ENG-SF19001-R7-9-CDs Summary_Markup Summary

ACCESS DRIVE
PLAN & PROFILE

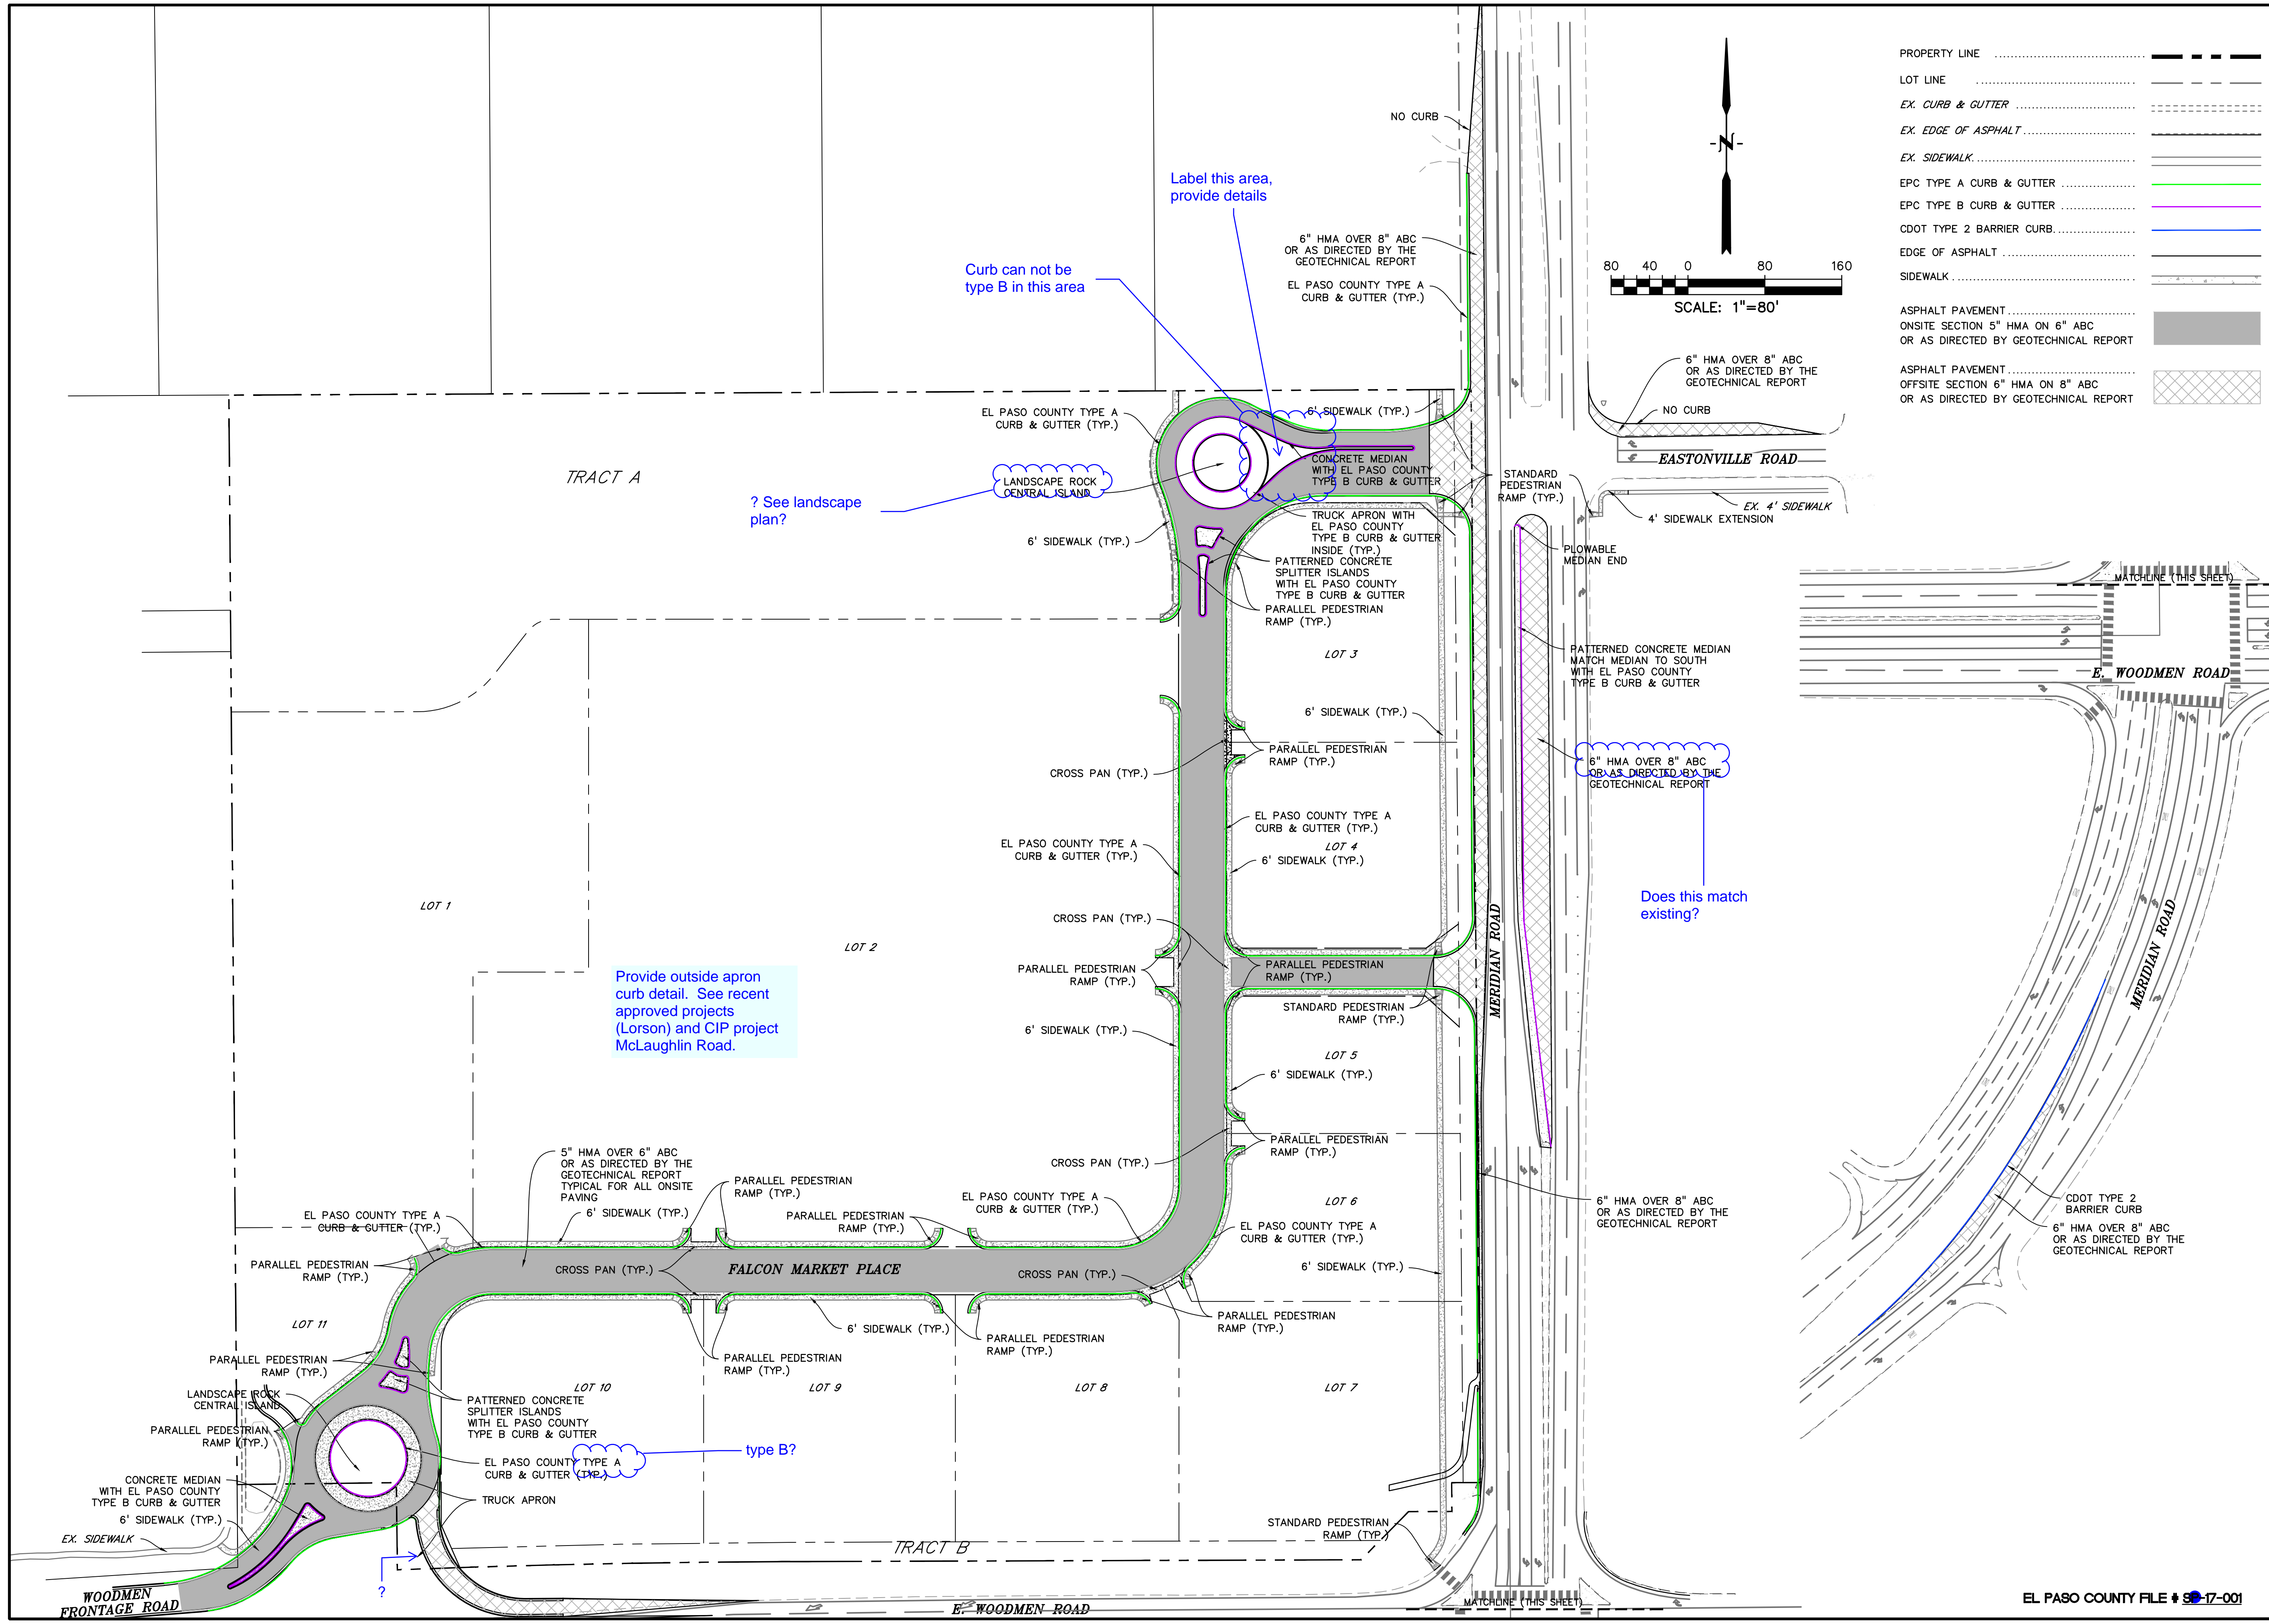
Access road needs to be 12% or less (10% per DCM 2)

SIGNAGE & STRIPING PLAN

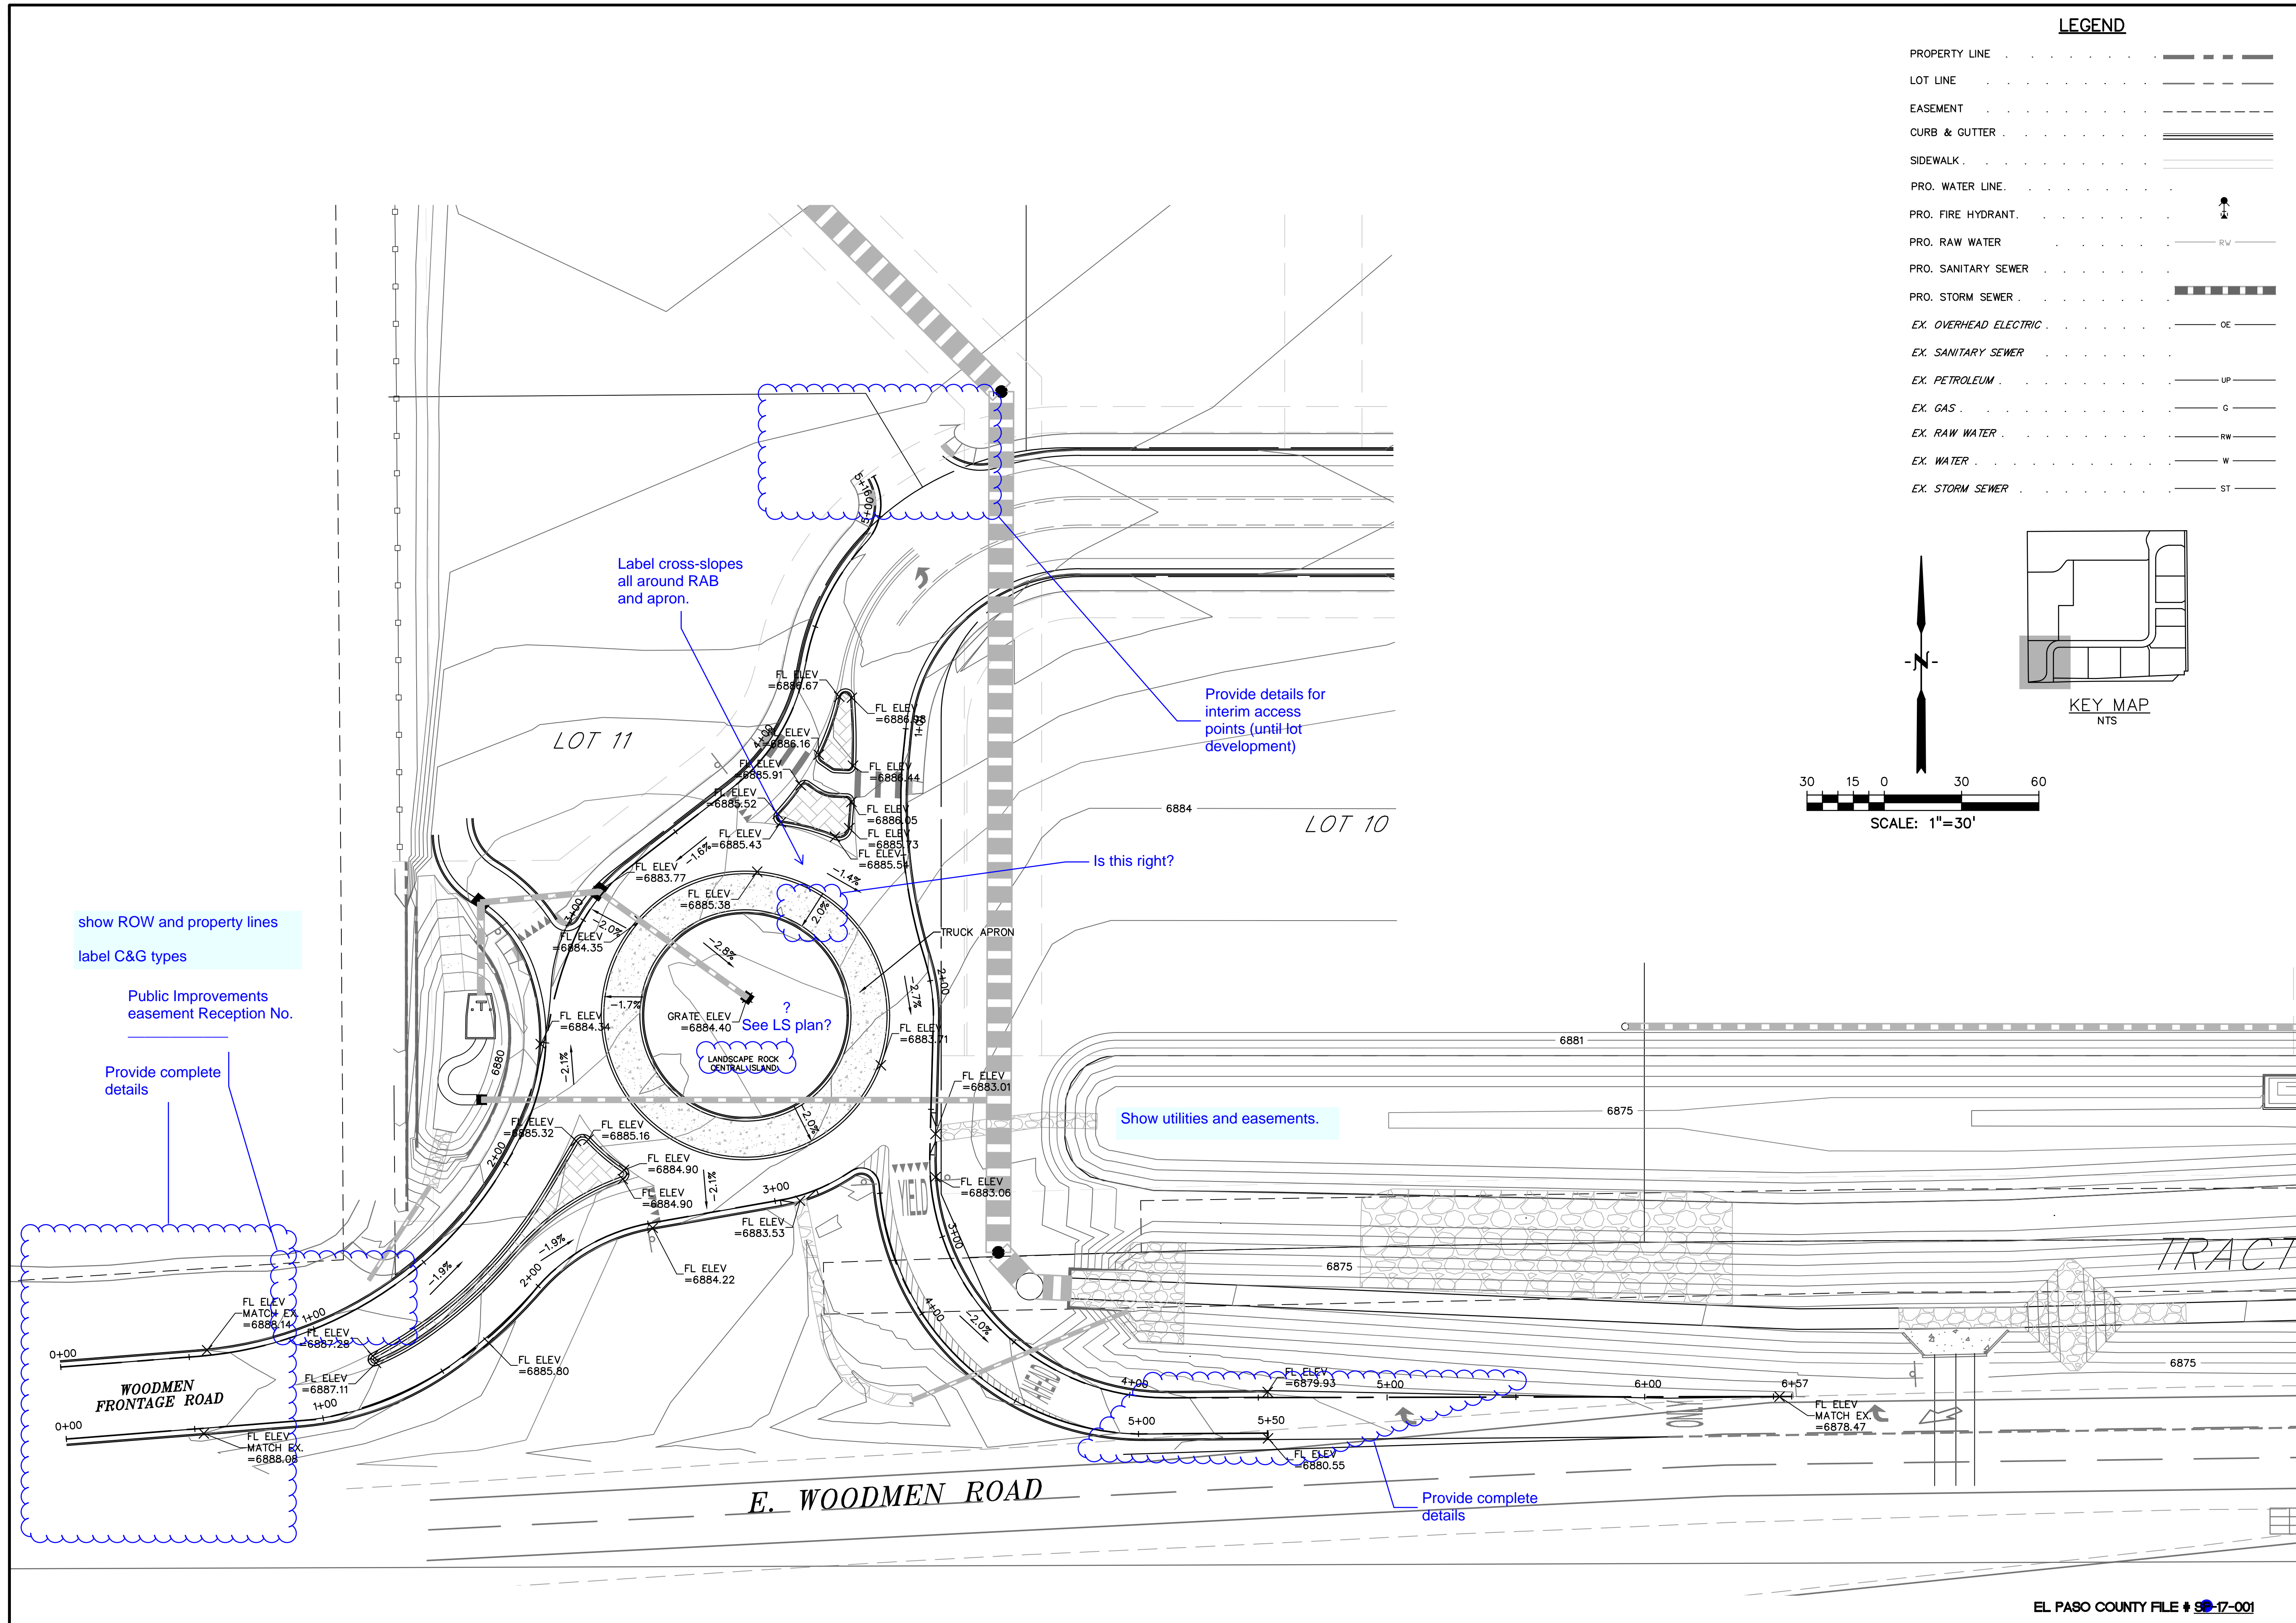
Stop bar?

Are landscape profiles going to be added?

arrows?

also on Meridian Road islands?
